**RE: DRB PROJECT NO. 1010999 - 3615 Highway 528
Grading & Drainage Comments**

We have addressed the DRB Comments provided by Abiel Carillo, P.E. at a hearing held on 12-14-2016. We offer the following responses to Mr. Carillo's comments:

**TRACTS C-4-A1 AND C-4-A2
SEVEN-BAR RANCH**

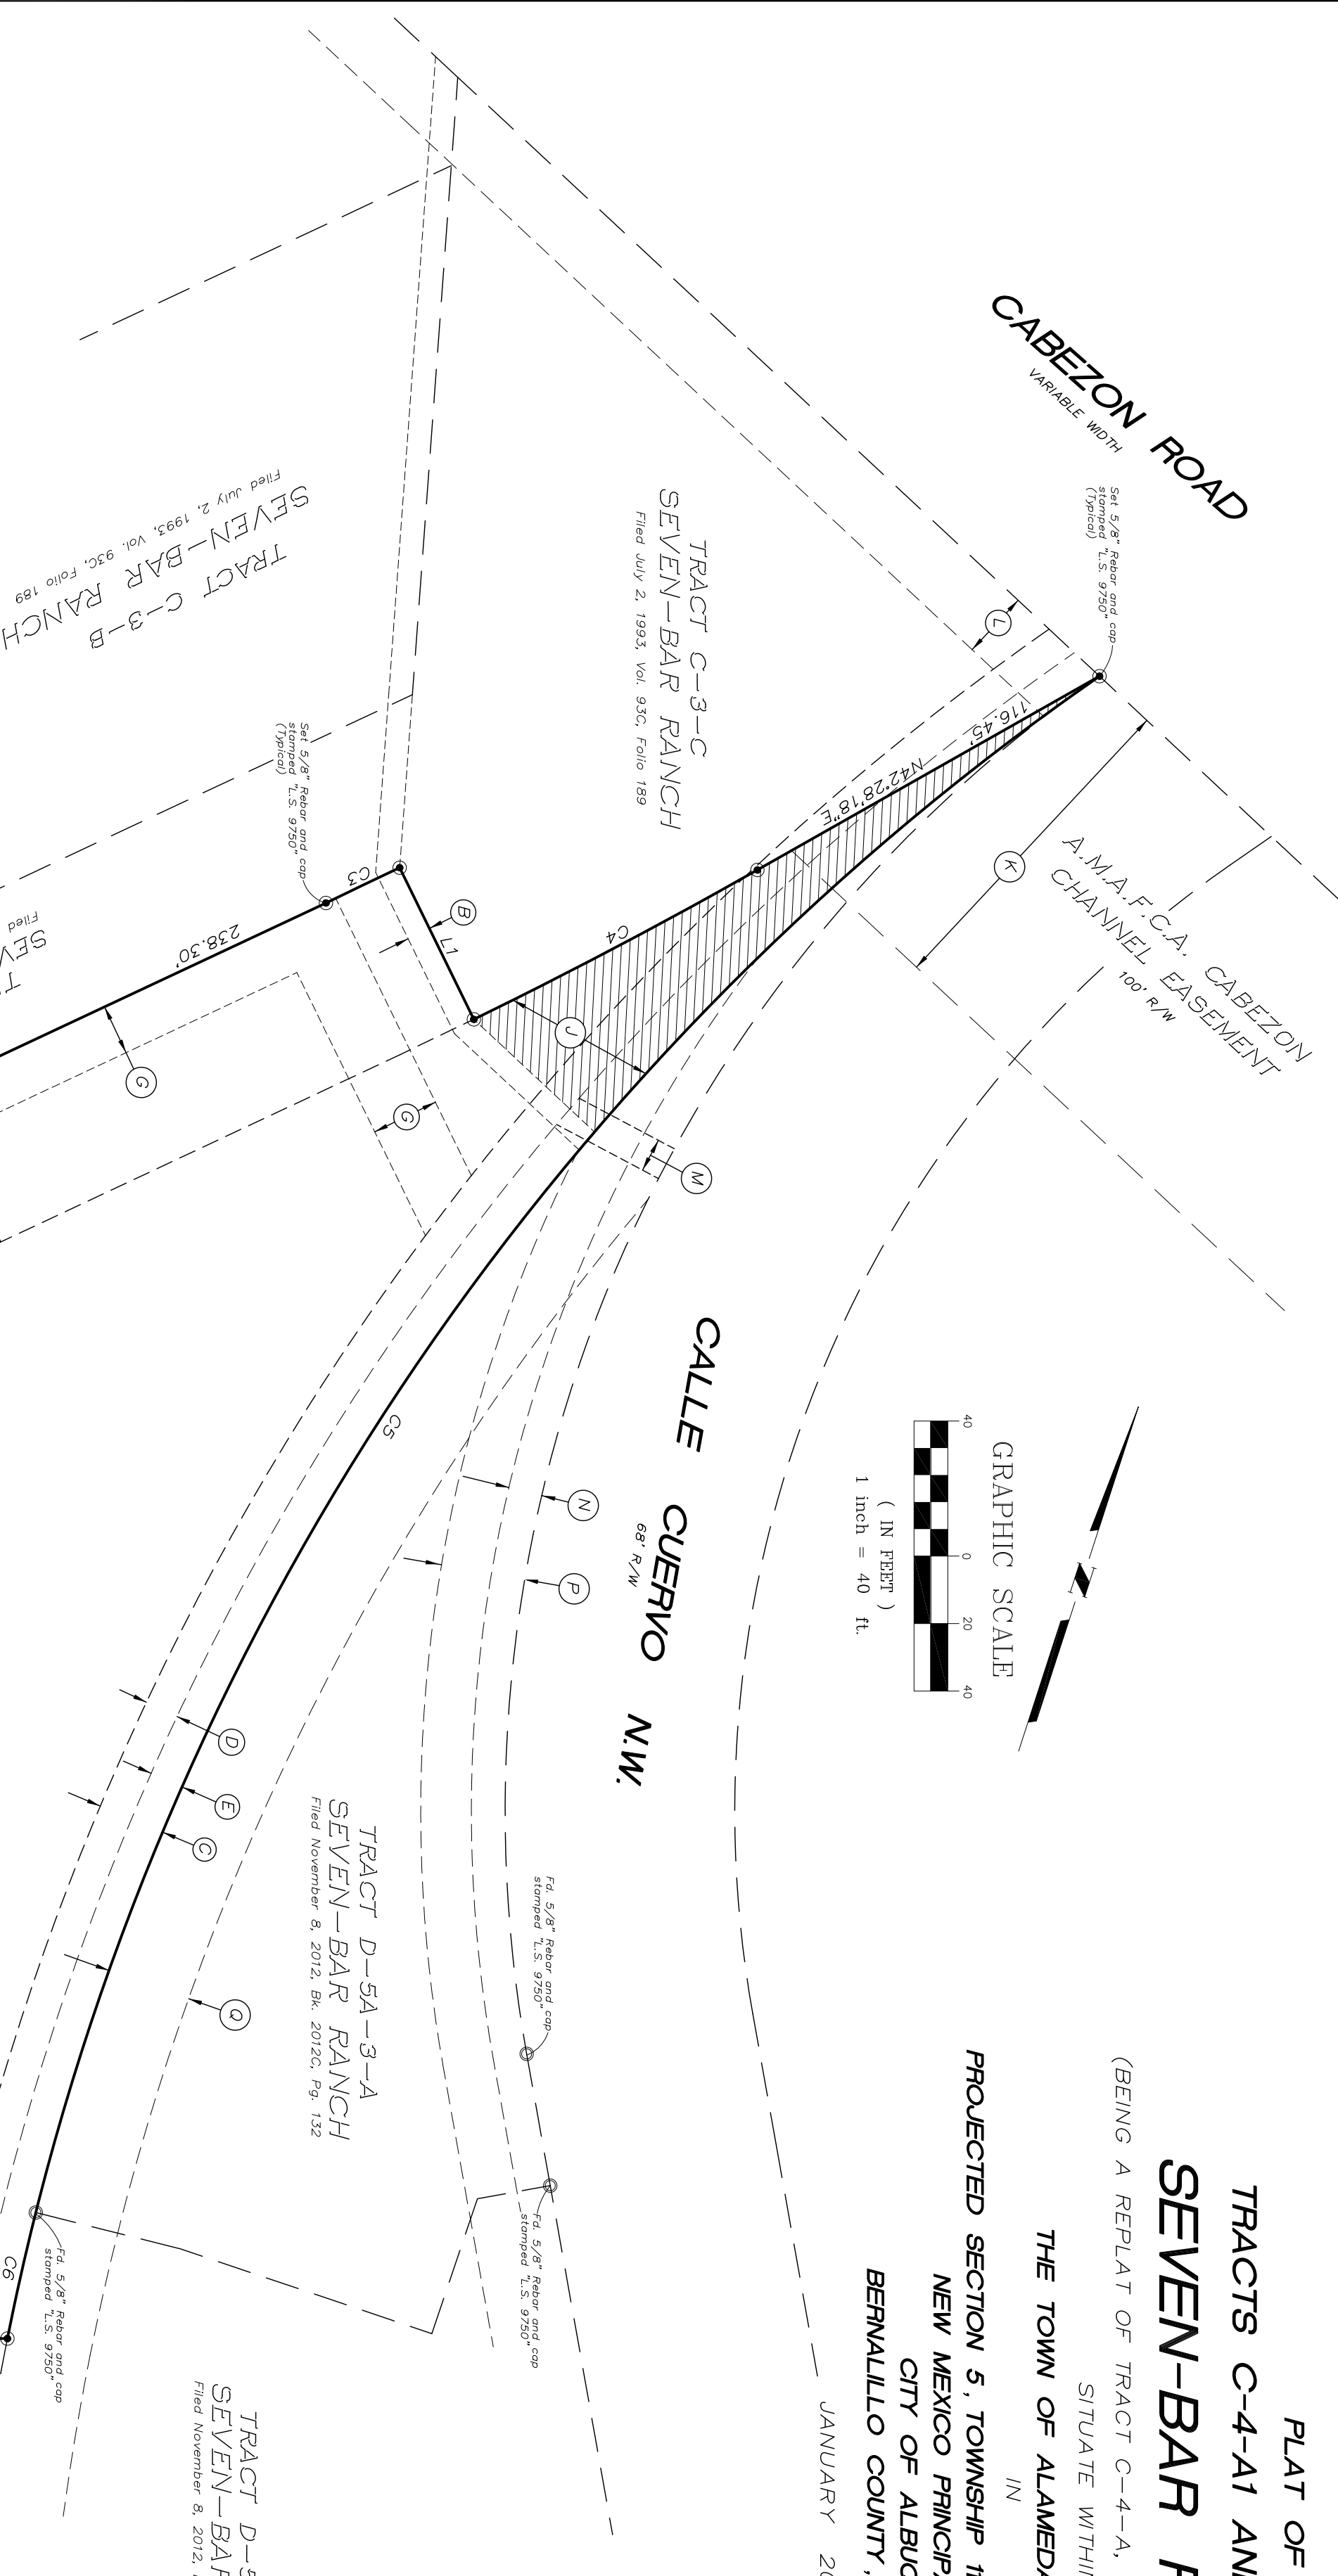
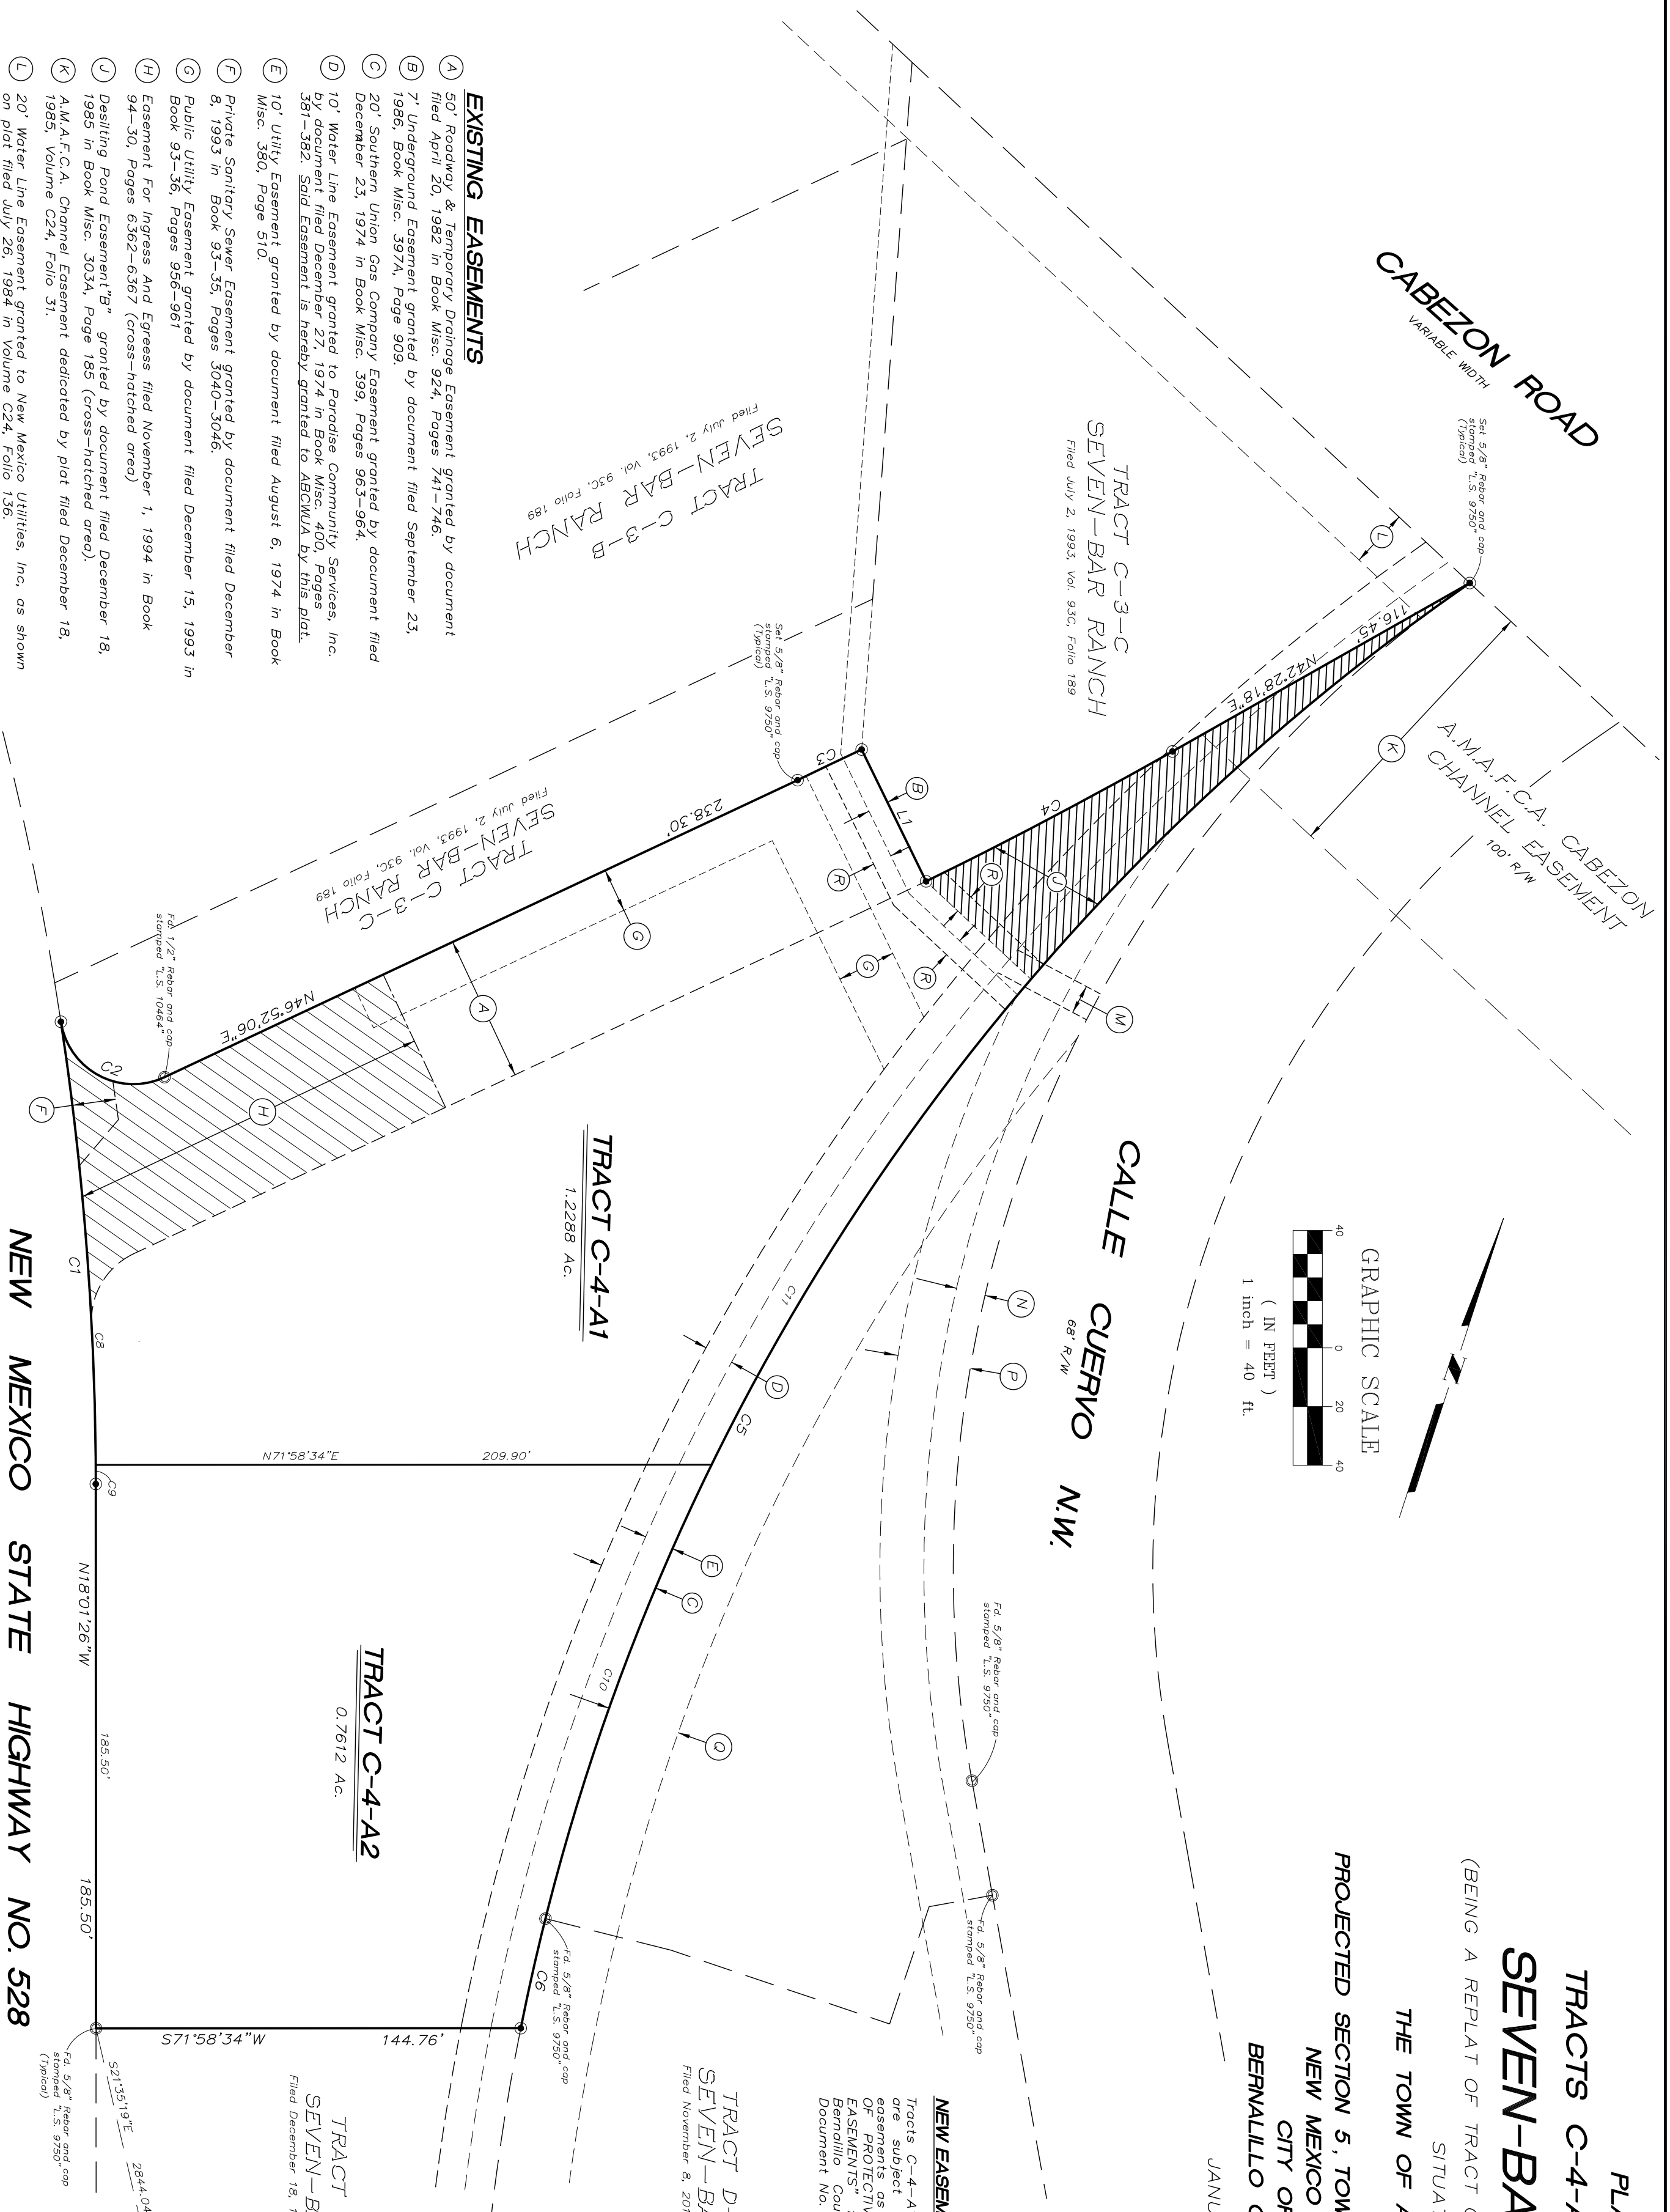
2. The Plat will need to include drainage easements since the proposed property line will run across the water quality pond, and flows will be conveyed across the new lot line.
The water quality pond that was situated on the proposed lot line has been deleted due to concerns about existing utilities under the proposed pond location.
